CITY OF ALBUQUERQUE

March 15, 2022

**Re: ABCWUA Backfill Screening Site – 5408 2nd St NW
Erosion and Sediment Control Plan
Engineer's Stamp Date 3/9/2022 (F15E056)**

ESC-1

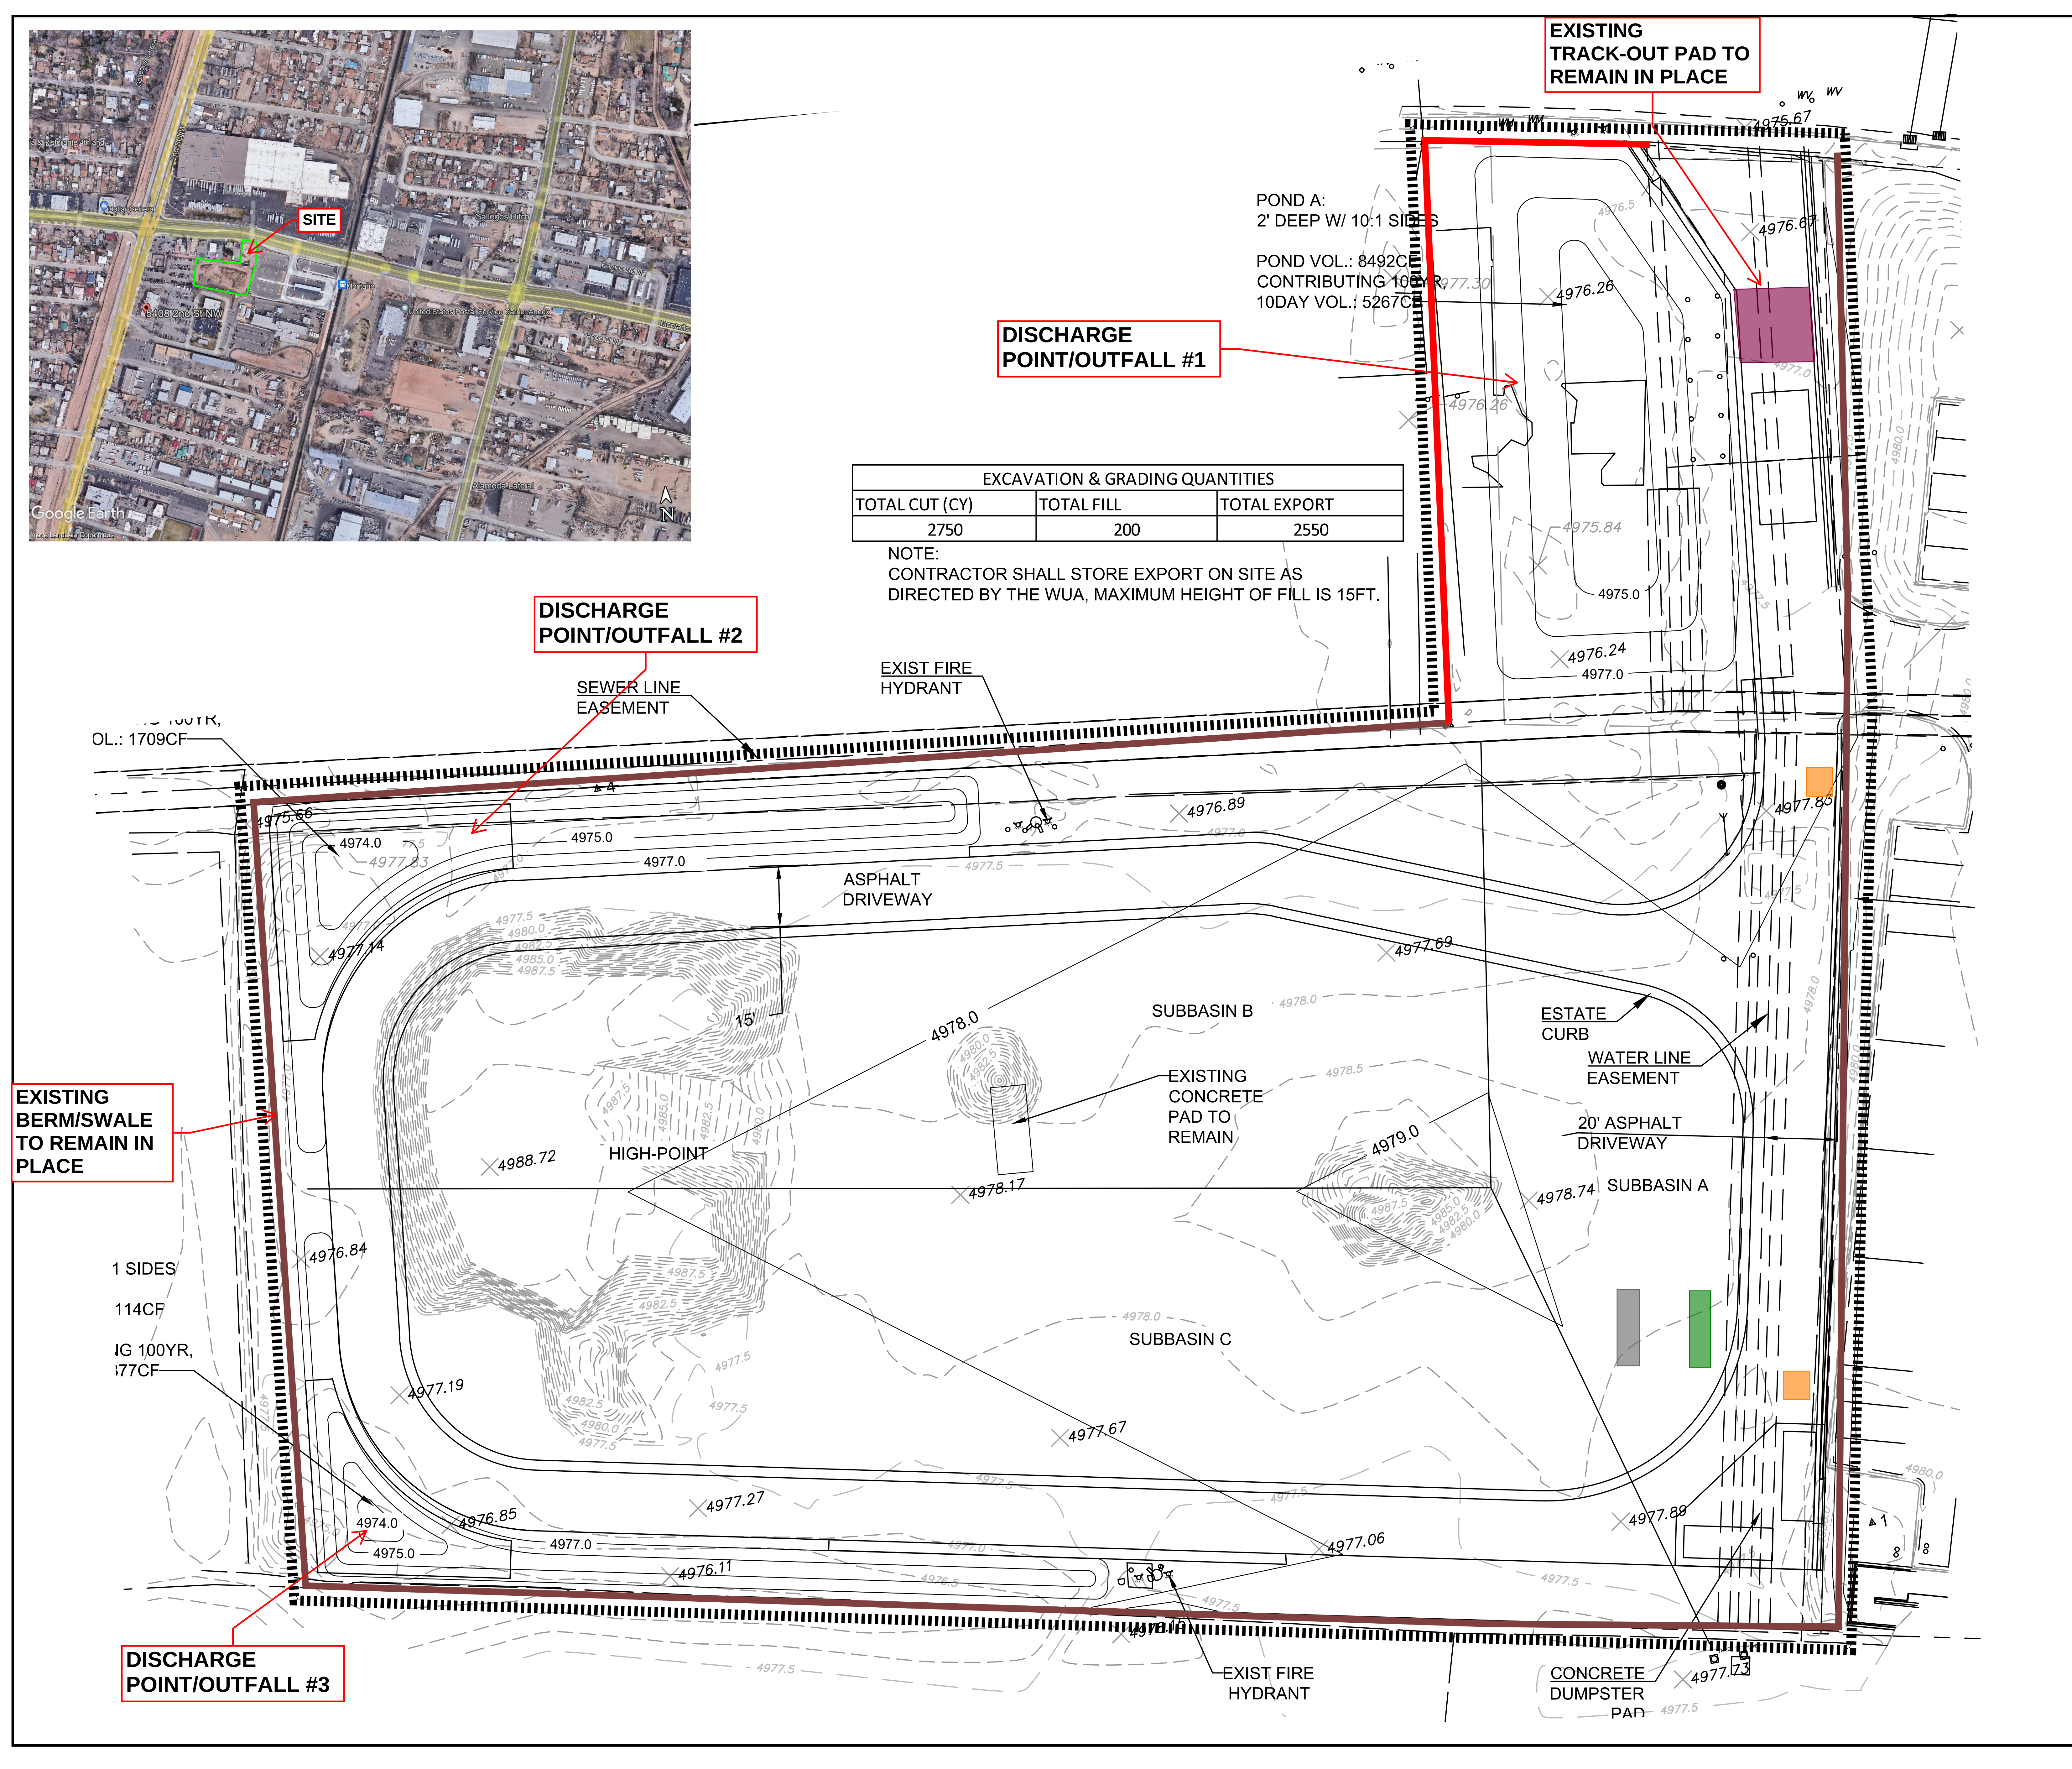
1. How will the site satisfy the Final Stabilization Criteria in CGP 2.2.14 before the project end date in the Low Erosivity Waiver (LEW)? If the site can't be stabilized in the time frame, then NPDES coverage is required.
2. The SWPPP must include site-specific interim and permanent stabilization per CGP 9.4.1.c.i. The Landscape Plan can be used to satisfy this requirement and should be submitted separate from the ESC Plan with the application to the Stormwater Quality Section of the Planning Department and they should be included in the SWPPP. Provide a specification on the ESC Plan for any disturbed areas not covered by the Landscape Plan.
